OXFORDSHIRE COUNTY COUNCIL'S RESPONSE TO CONSULTATION ON THE FOLLOWING DEVELOPMENT PROPOSAL

Application no: 22/02866/OUT

Proposal: OUTLINE planning application for up to 120 dwellings, vehicular and pedestrian access off Ploughley Road, new pedestrian access to West Hawthorn Road, surface water drainage, foul water drainage, landscaping, public open space, biodiversity and associated infrastructure. Access off Ploughley Road is not reserved for future consideration

Location: Land East Of, Ploughley Road, Ambrosden

PROPOSED CYCLE ACCESS  
SCALE 1:100

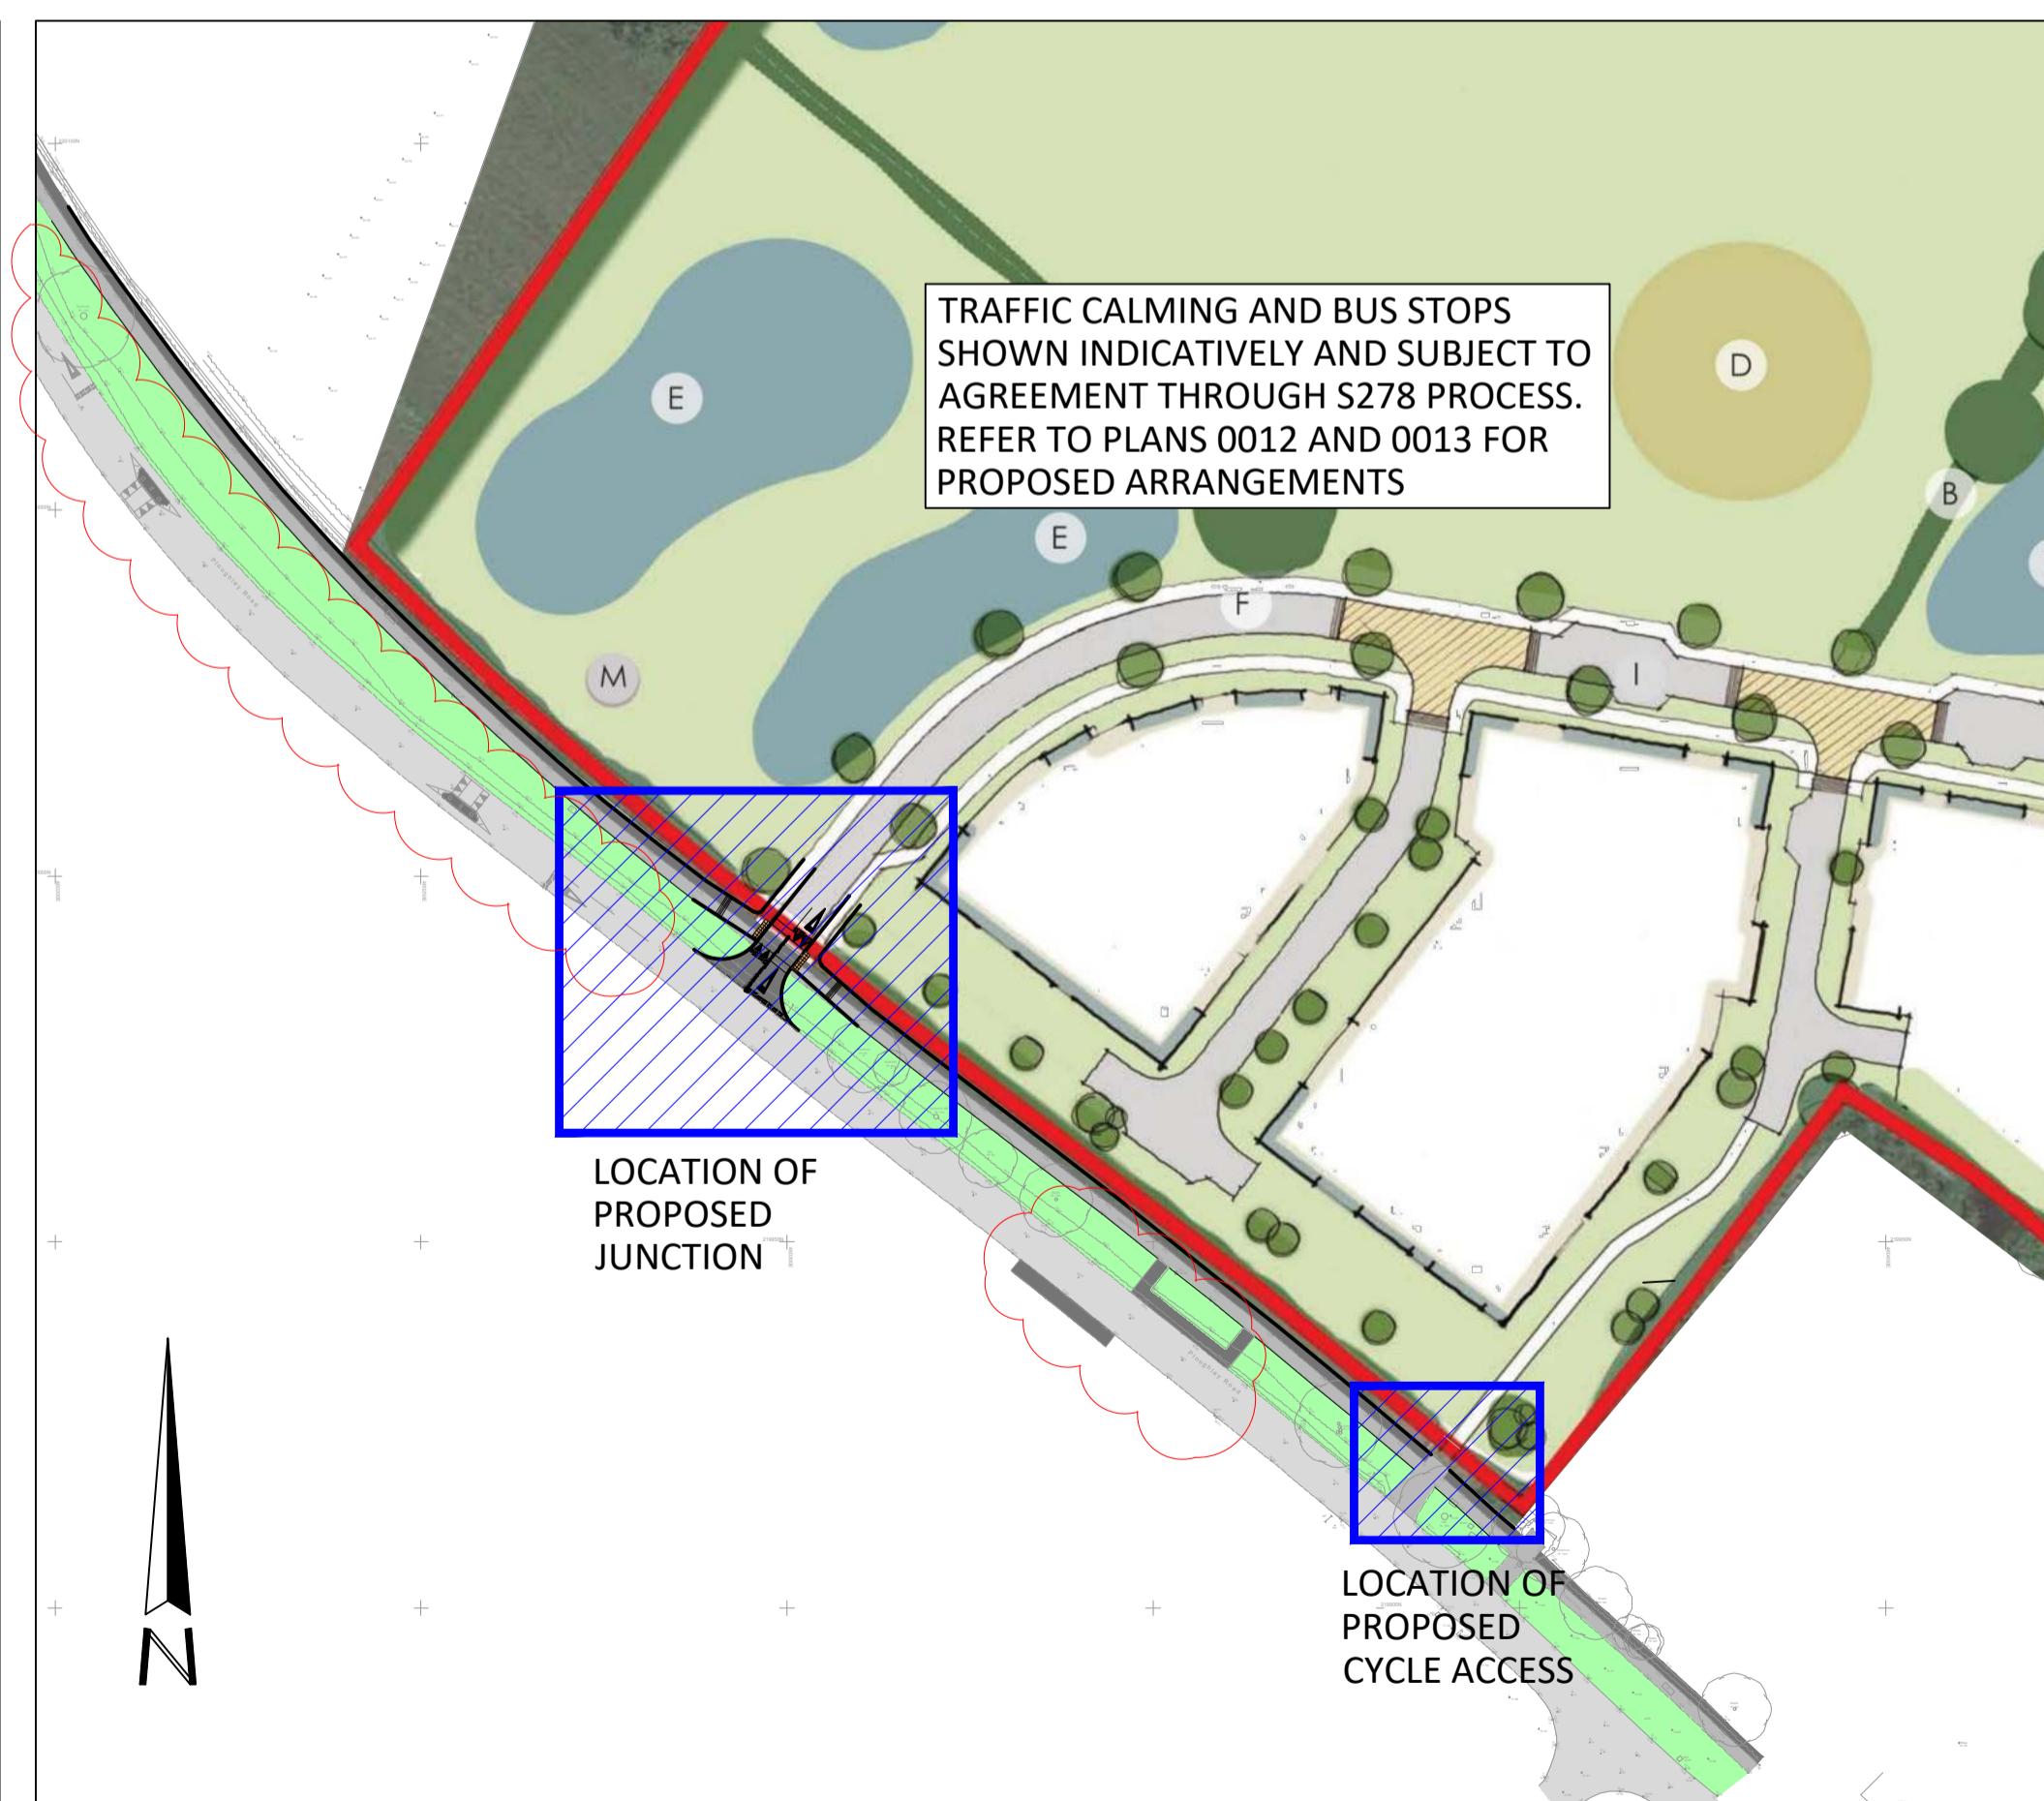
An indicative junction access plan is included in the Design & Access Statement (DAS) and Appendix D of the Transport Assessment (TA). The centreline of the access is approximately 18m from the trunk of a Hawthorn tree in the highway verge.

The TA says that visibility splays of 70m will be provided and I agree that this distance can be achieved in both directions, assuming that the tree growth is managed and the verge vegetation is kept to an appropriate height. The access will be a significant distance from the built-up area of Ambrosden and relatively close to the (relocated) speed limit boundary between 30mph and the 60mph National Speed Limit (NSL). Therefore, it is not definitive which standards should be used for establishing visibility criteria – both Manual for Streets (MfS) and the Design Manual for Roads and Bridges (DMRB) need to be considered.

According to the calculation in MfS, a 70m Stopping Sight Distance (SSD) is equivalent to 43mph. However, MfS is only applicable up to speeds of 37mph.

According to DMRB, a 70m SSD is equivalent to 32mph.

The built-up area effectively ends at the entrance to the Bicester Garrison centre, 160m from the site access, and there is no streetlighting north of there, so it is highly likely that the majority of outbound vehicles will significantly accelerate, despite remaining in the proposed 30mph area that will only be indicated by speed limit repeater signs. Indeed, any overtaking manoeuvres on exit from the village may result in the faster vehicle proceeding northwards in the southbound lane, significantly reducing the visibility from the site access.

Southbound vehicles from the A41 will leave the NSL at a point which is proposed to be about 100m from the site access. It is considered that most vehicles will not decelerate fast enough to be moving at a speed appropriate to the visibility splay length when they first come into view.

Given the above, OCC consider that the available visibility from the site access is insufficient for the anticipated vehicle speeds along Ploughley Road, despite the proposed change to the speed limit, and this is a reason to **object**.

The bellmouth access must include a cycletrack crossing in accordance with LTN 1/20, as noted in sect. 5.3 of the TA.

OCC believe that the introduction of traffic-calming measures could potentially ensure that vehicle speeds are reduced to acceptable levels. There is a valid precedent on Ploughley Road at the south side of the village where two build-out features have been approved and constructed.

A similar proposal adjacent to the site may be appropriate. If the application is to be approved, OCC require suitable traffic-calming measures to be provided as part of the S278 works. Any features must be designed to accommodate oversize military vehicles and large agricultural plant, and any vertical deflections along a bus route are subject to agreement with the bus operators.
